Building Code of Australia

Assessment Report

**Project Address: Telopea Stage 1A, Lot 5-7 Sturt
Street, Telopea**

Revision: R04

DRAWING TITLE
LEVEL 02 FLOOR PLAN

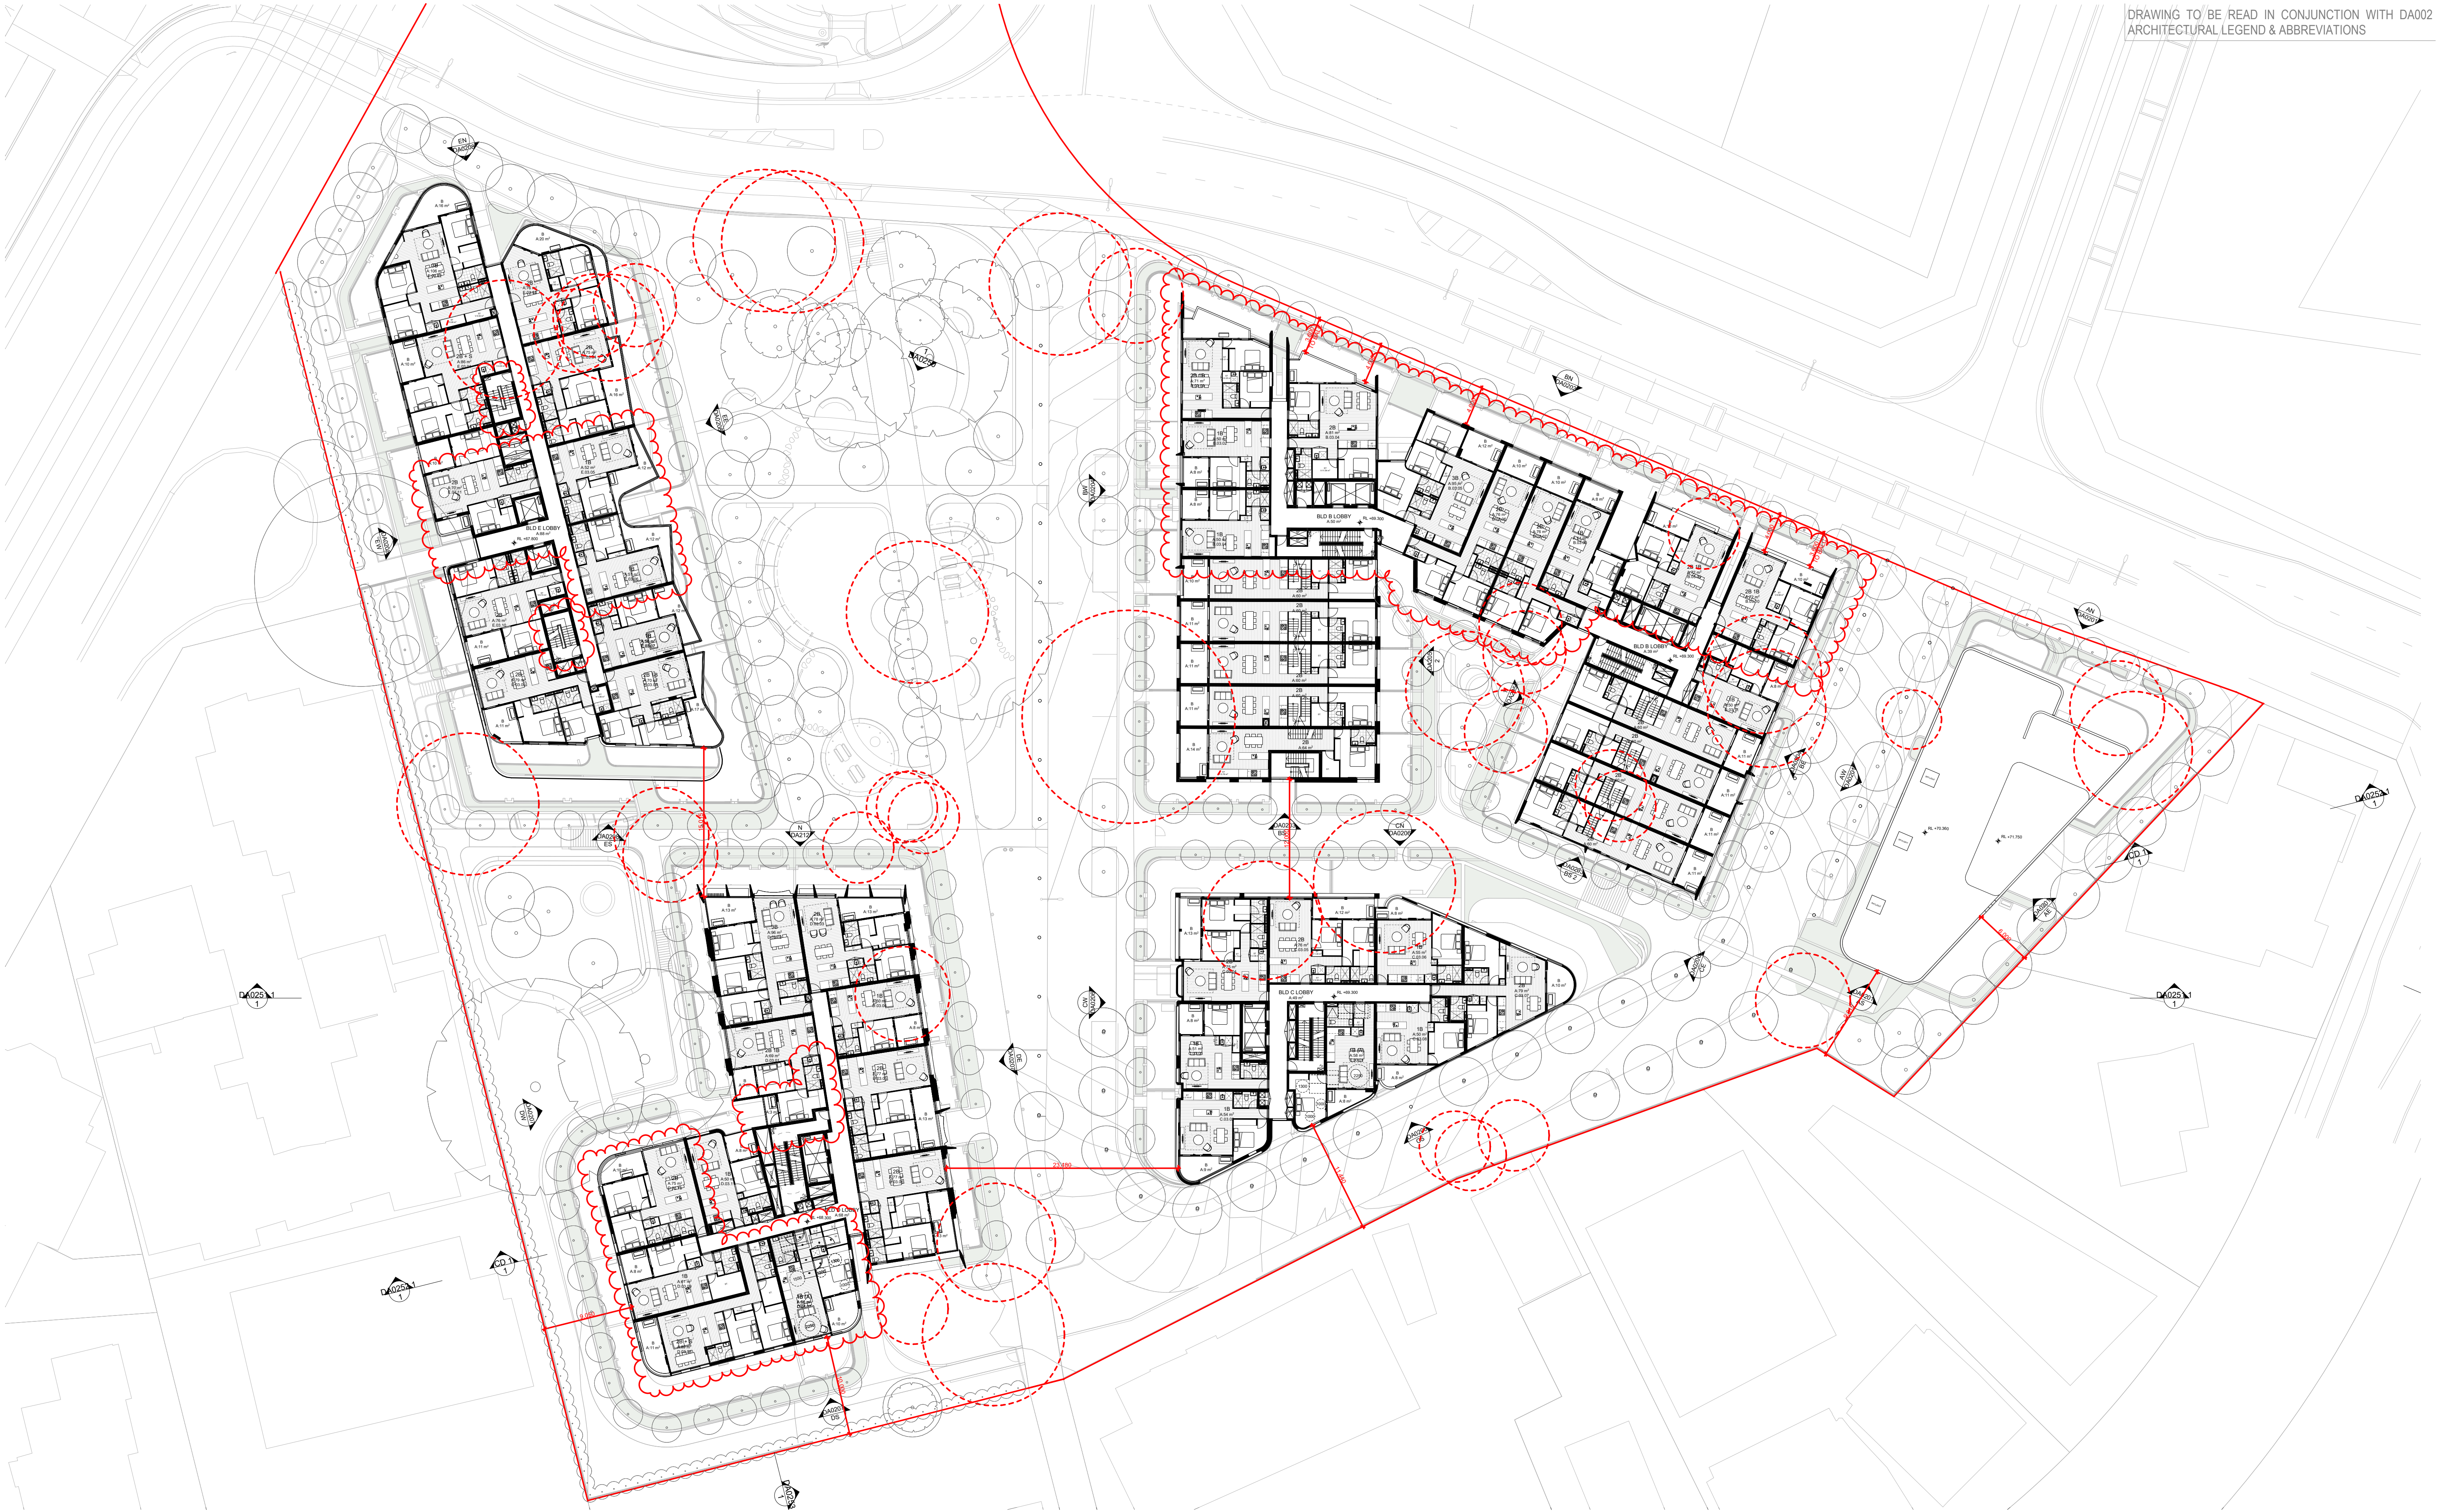
Clause	Performance justification
C3D15 Public corridors in Class 2 and 3 Buildings	The following public corridors exceed 40m without smoke proof walls: Tower B - Upper ground floor Approx. 53 - L2 Approx. 48.2m. Tower D - Upper ground floor Approx. 46m. Tower E - Upper ground floor Approx. 57m - L1 – L8 Approx. 51.4m..
